**KIRKLEES METROPOLITAN COUNCIL
INVESTMENT & REGENERATION SERVICE**

Reference No: 2018/62/94137/W

Site Address: 75-77, Springdale Street, Thornton Lodge,
Huddersfield, HD1 3NF

Description: Erection of single storey side extension

SIDE ELEVATION
75/77 SPRINGDALE STREET
THORNTON LODGE HUDDERSFIELD
DRG NO 1851-8 SCALE 1:50

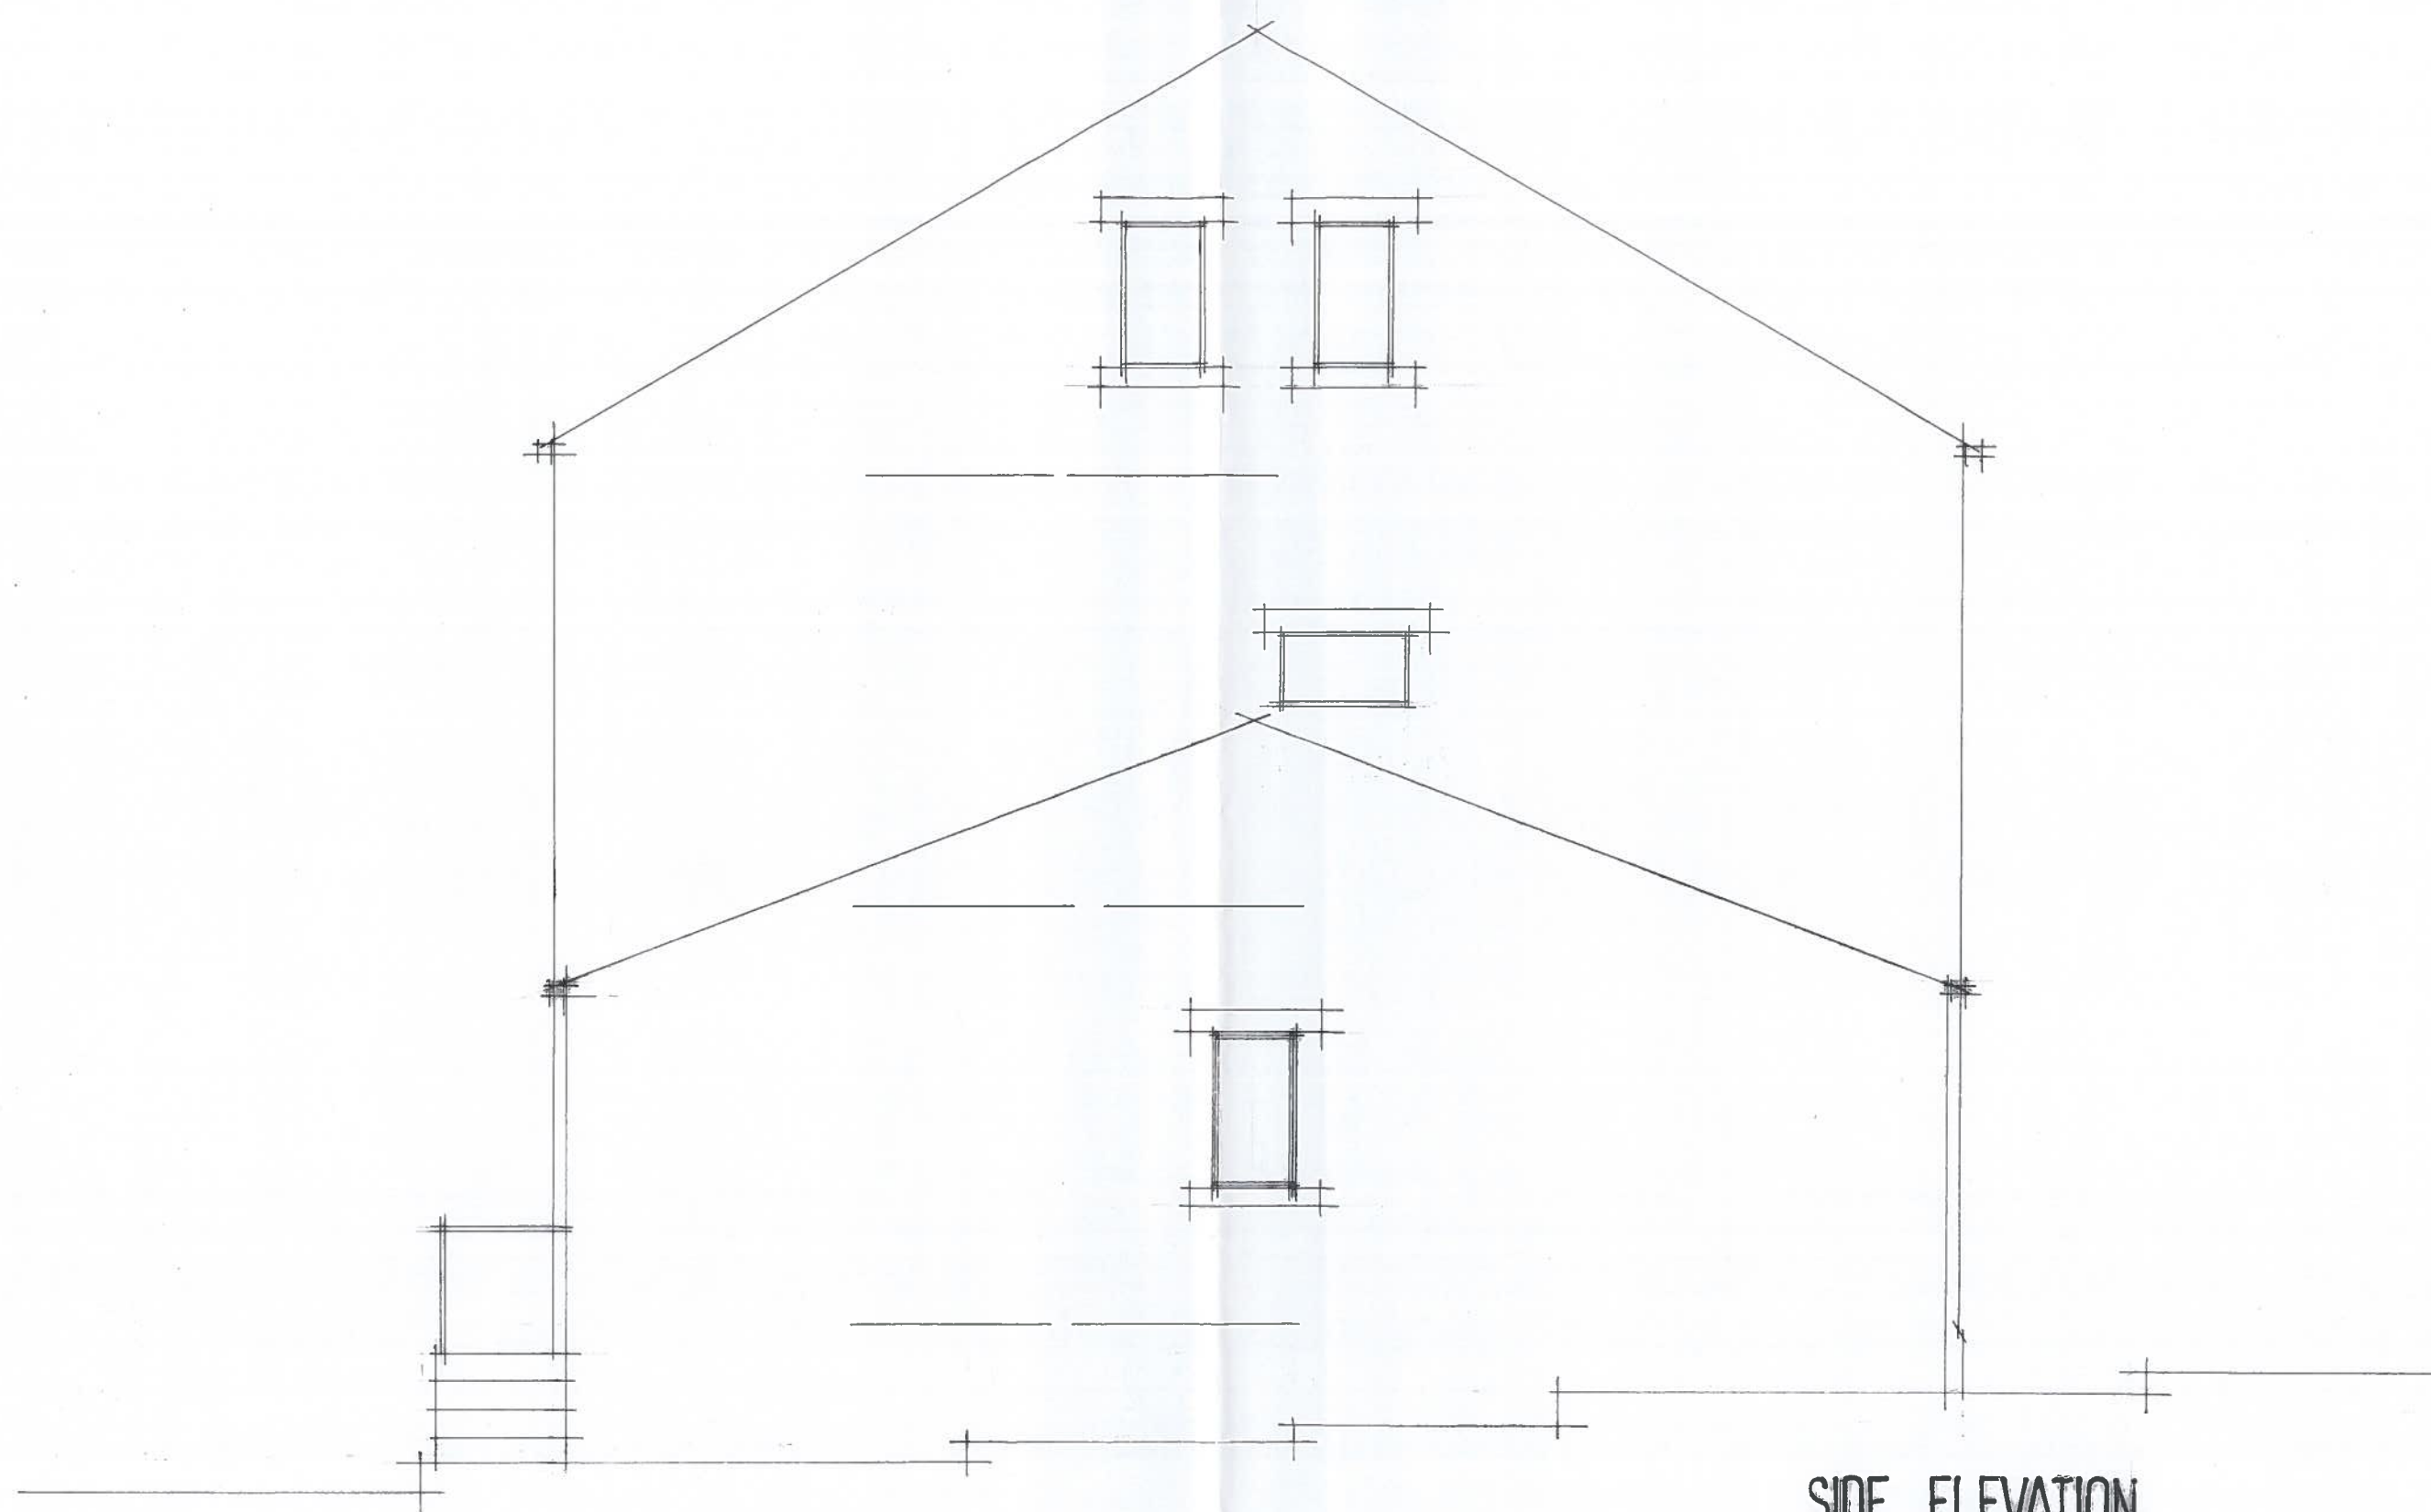
3. The development shall not be occupied until the 1no. window in the north side elevation as show on drawing 1851.8, of the extension hereby approved have been obscure glazed. Notwithstanding the provisions of the Town and Country Planning (General Permitted Development) (England) Order 2015 as amended (or any Order revoking or re-enacting that Order) the obscure glazing shall thereafter be retained for the lifetime of the development.
